25 May 2016

File Number: 2014/6724
Our Ref: R/2014/35/C

RE: SSD 6724 MOD 1 – Modification Application – Student Accommodation Development at 60-78 Regent St, Redfern

60-78 Regent St
Redfern
Ground Floor Plan

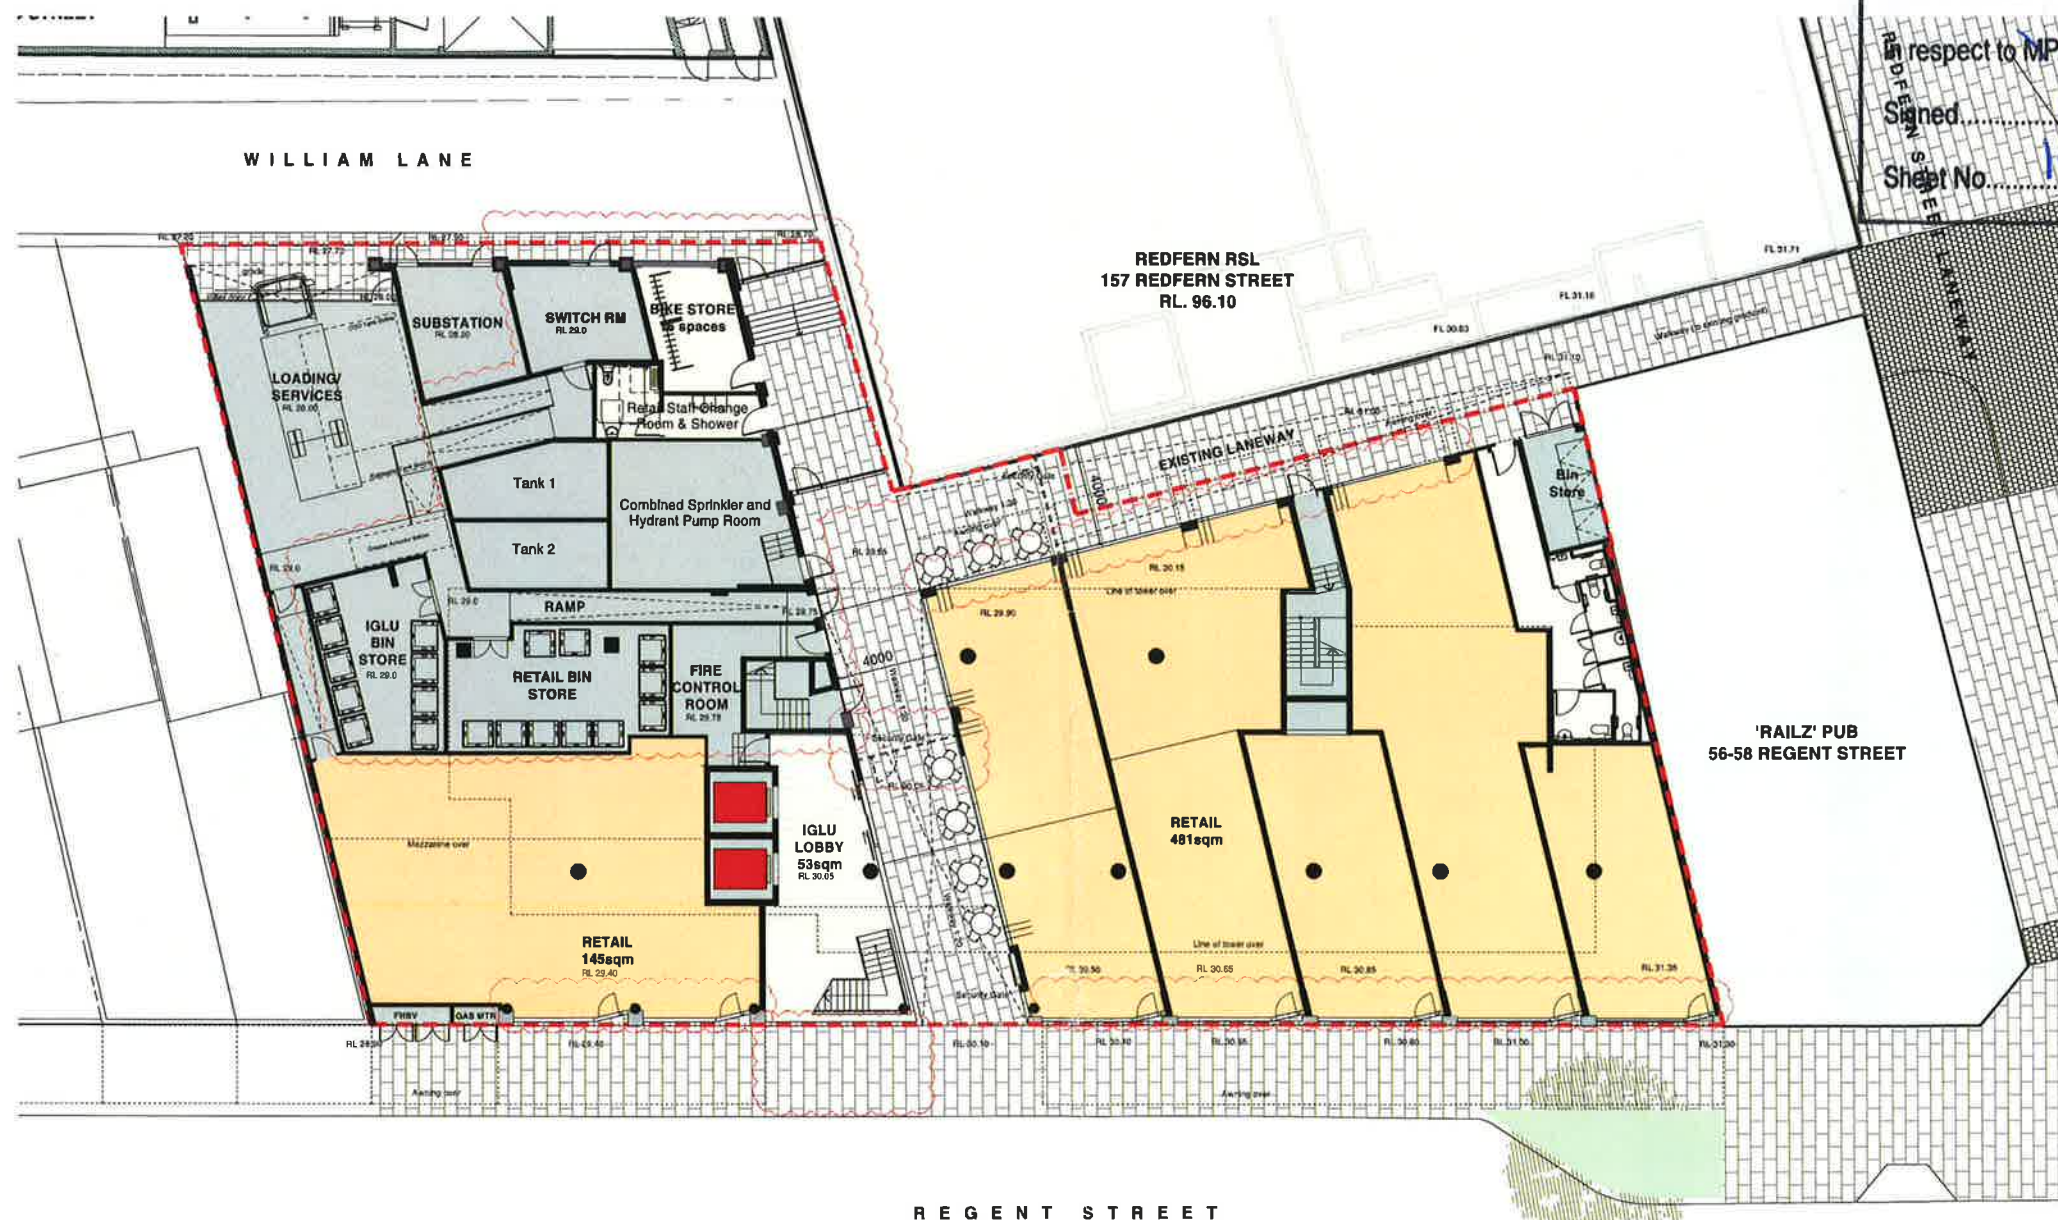
Relocation of the Community Space also compromises upon the northern end of William Lane, creating blank frontages in a previously active space. However, it appears the proposal attempts to offset this by opening the retail shopfronts to the Existing Lane, activating what were originally blank walls. In terms of the activation of the Existing Lane, this is an improvement. But offset from the loss of a truly accessible publicly accessible Community Space. In this regard, it is a less than neutral outcome.

60-78 Regent St
Redfern
Podium plan
Level 01

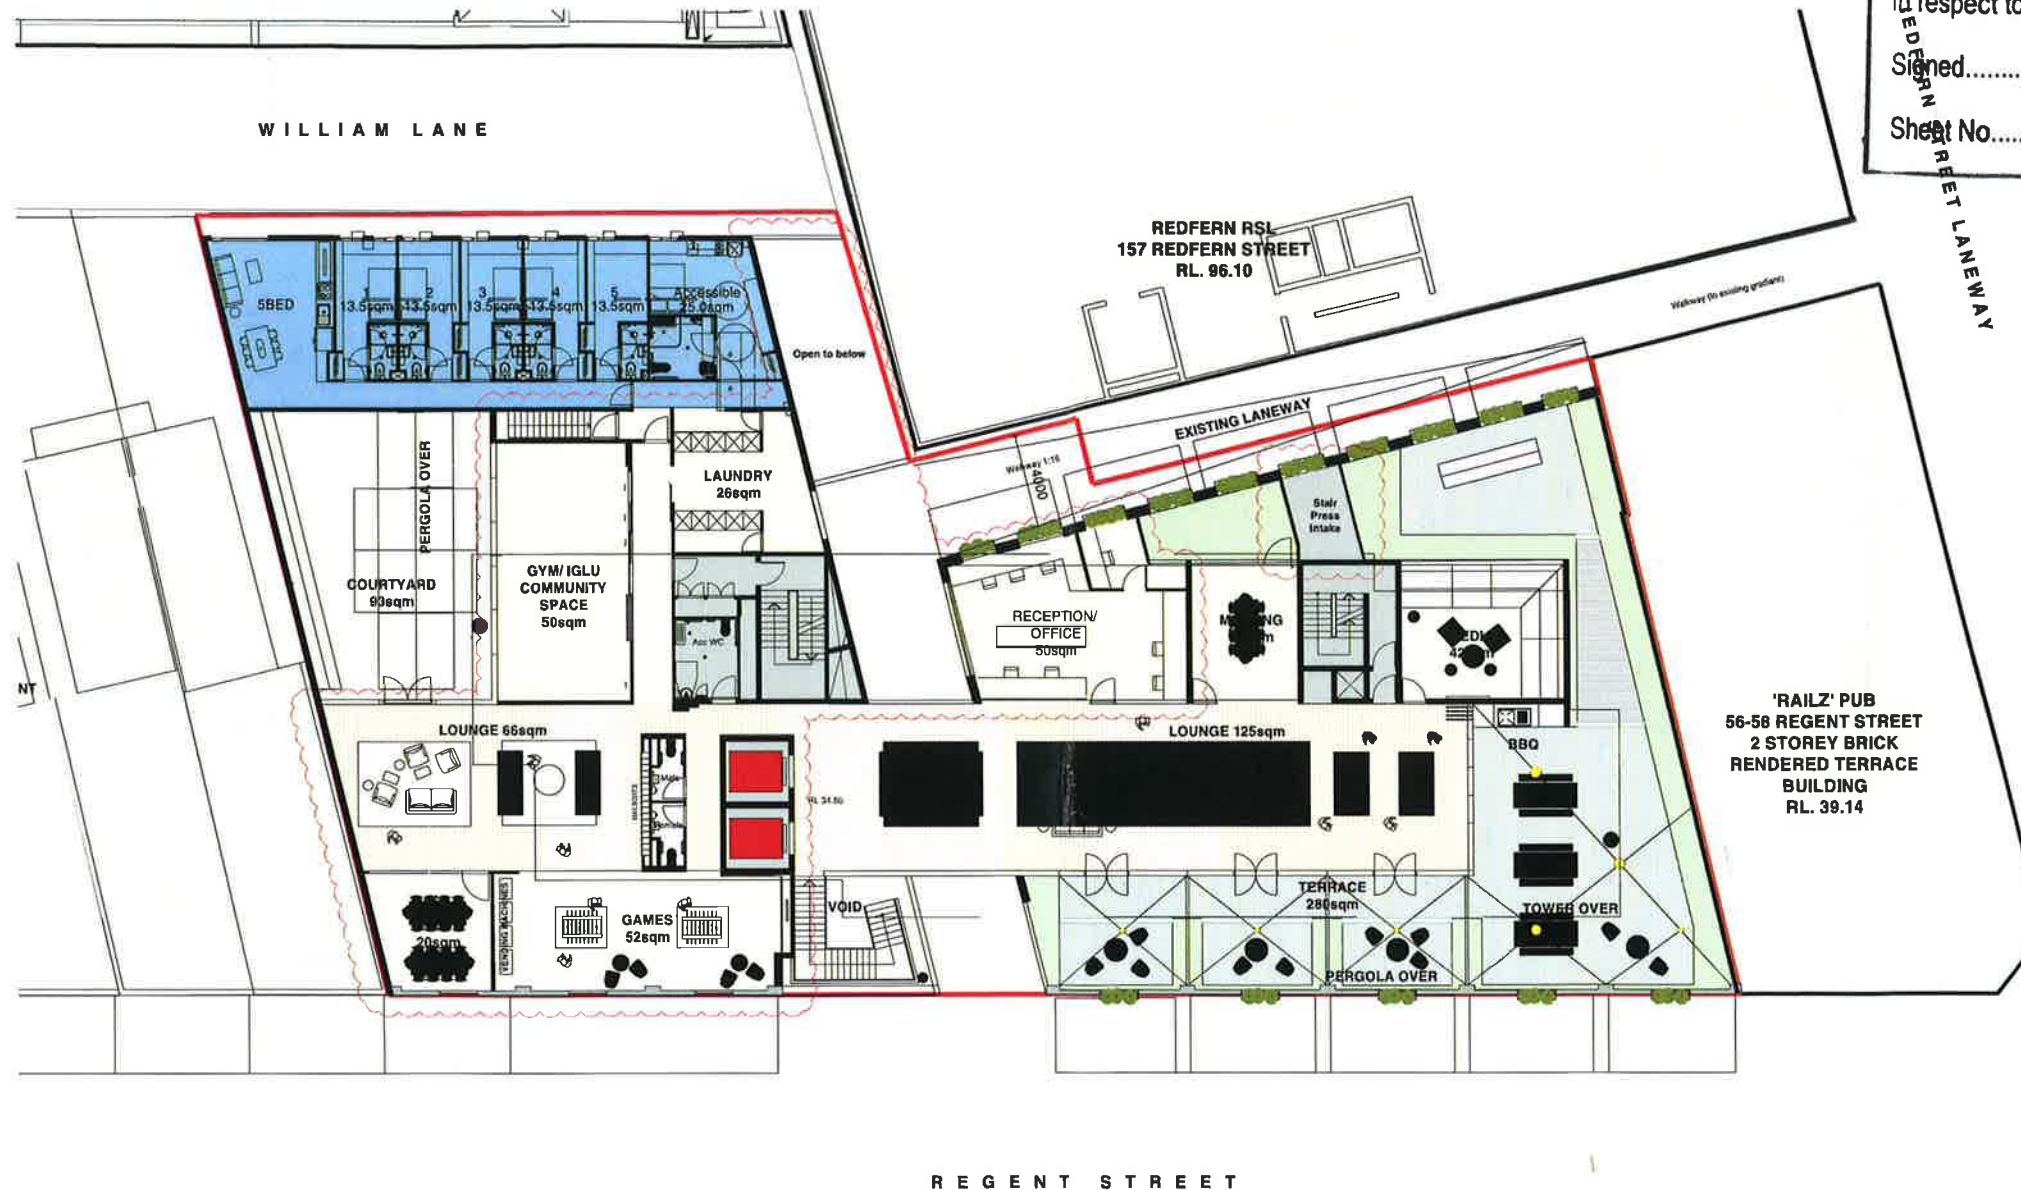
As approved, the development included a ‘Community Space’ to William Lane with exclusive entries to each of its frontages. This space appeared publicly accessible, providing a potential public benefit to the Redfern Community. As amended, the ‘Community Space’ will be relocated to Level 1 and renamed ‘Iglu Community Space’. Both the relocation and renaming of the room indicate privatisation of the space for the exclusive use by Iglu residents.

The ‘Community Space’ has also been reduced in size but intensified in its function, now accommodating a gym. The ‘active’ nature of the gym/community room will extend into the courtyard, potentially impacting upon the proposed residential building located on 80 Regent Street.

The optimum outcome would involve the activation of the Existing Lane with the new shopfronts and maintaining the Community Room accessible from William and the Existing Lanes.

There is an outdoor space that is only accessible from the meeting room and planter boxes to the Existing Laneway. All of these elements are supportable, however, it does raise the question of maintenance, acknowledging that these areas are likely to be paved rather than 'green' as shown in the drawings

60-78 Regent St
Redfern
West Elevation

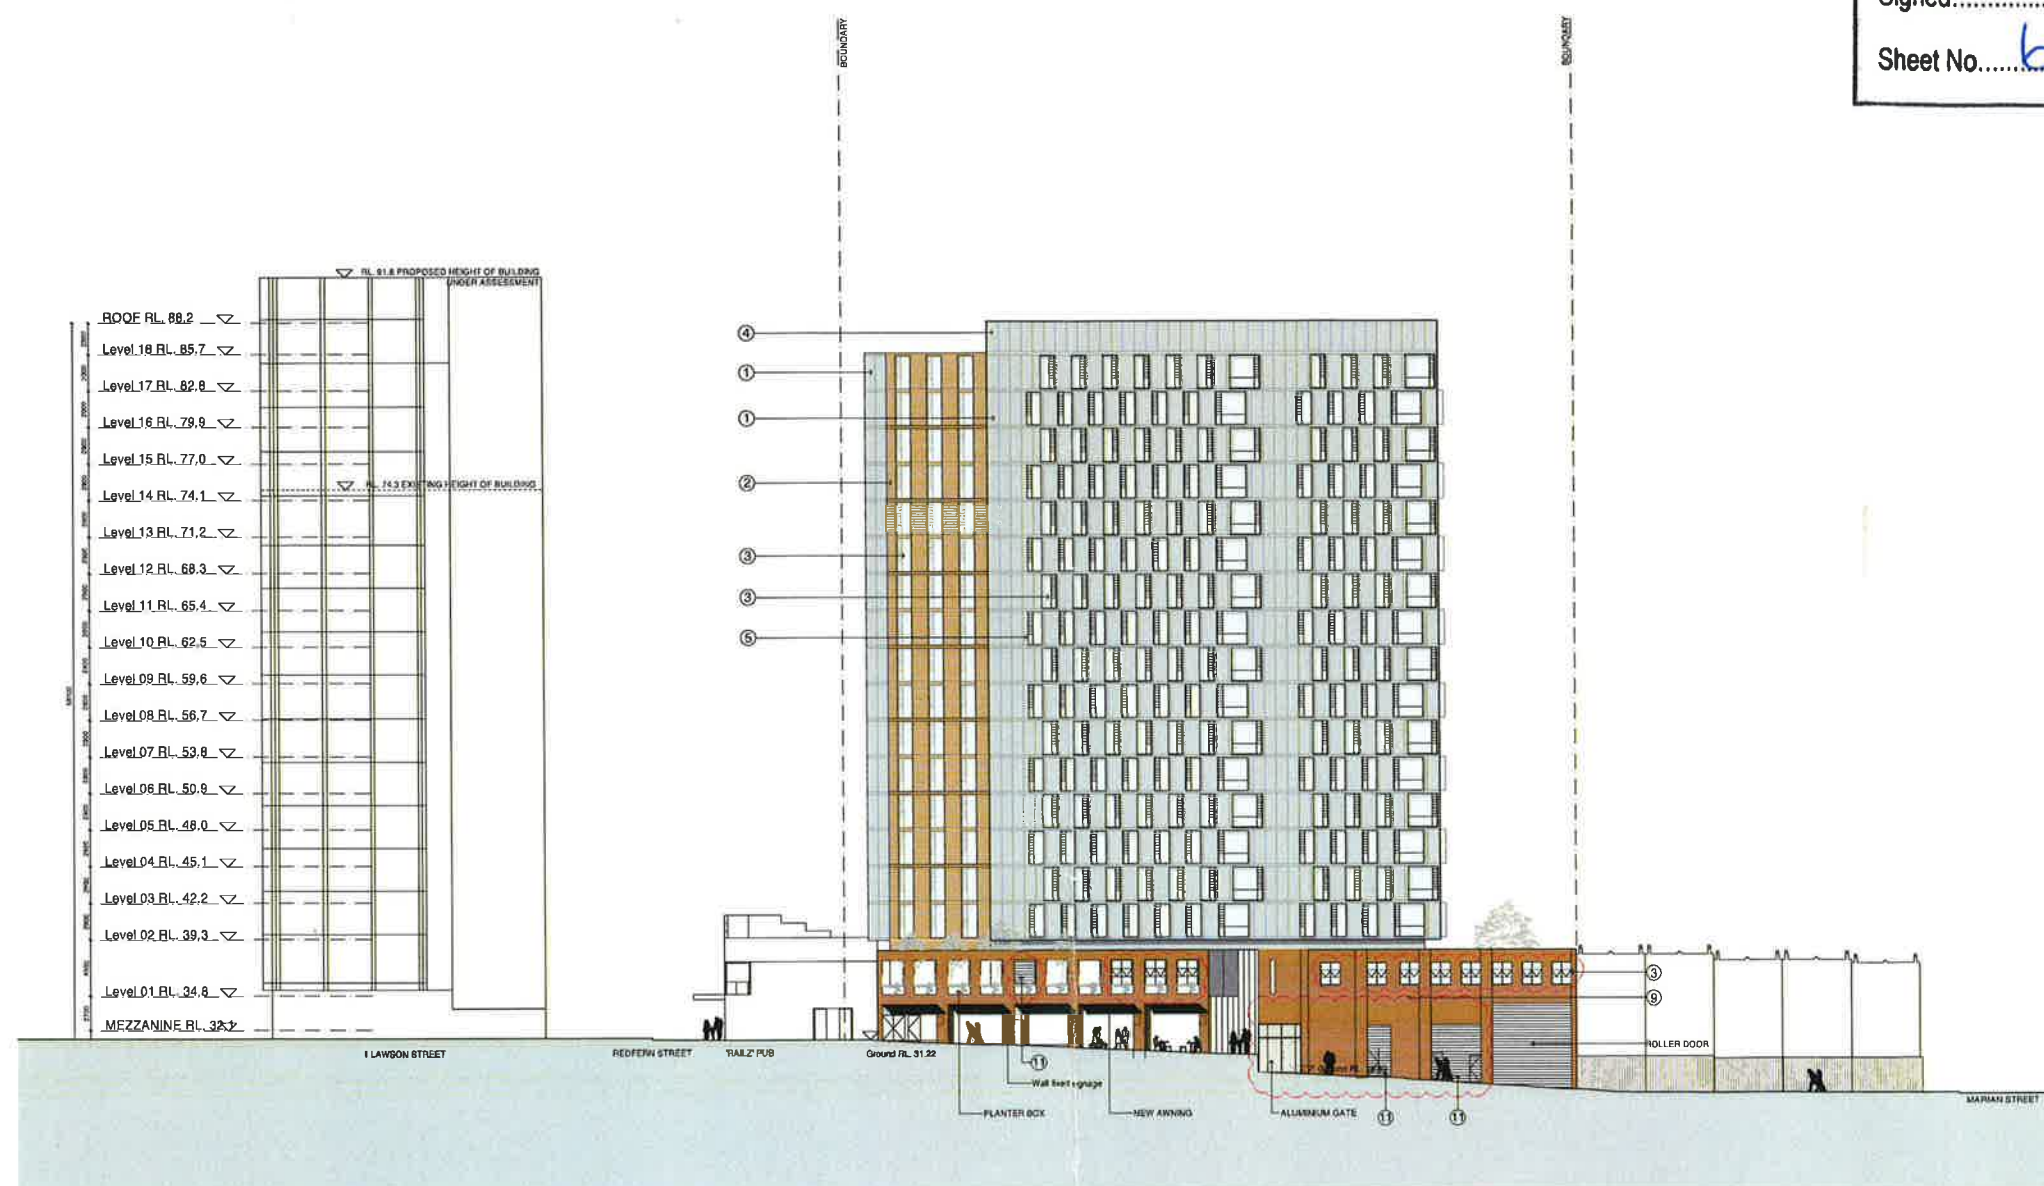
In the West elevation there are windows that are identified as: 3. *Window system Vision glass, glass louvres & spandrel*. This does not match what has been drawn which are more like an awning window system with no louvres or spandrel.
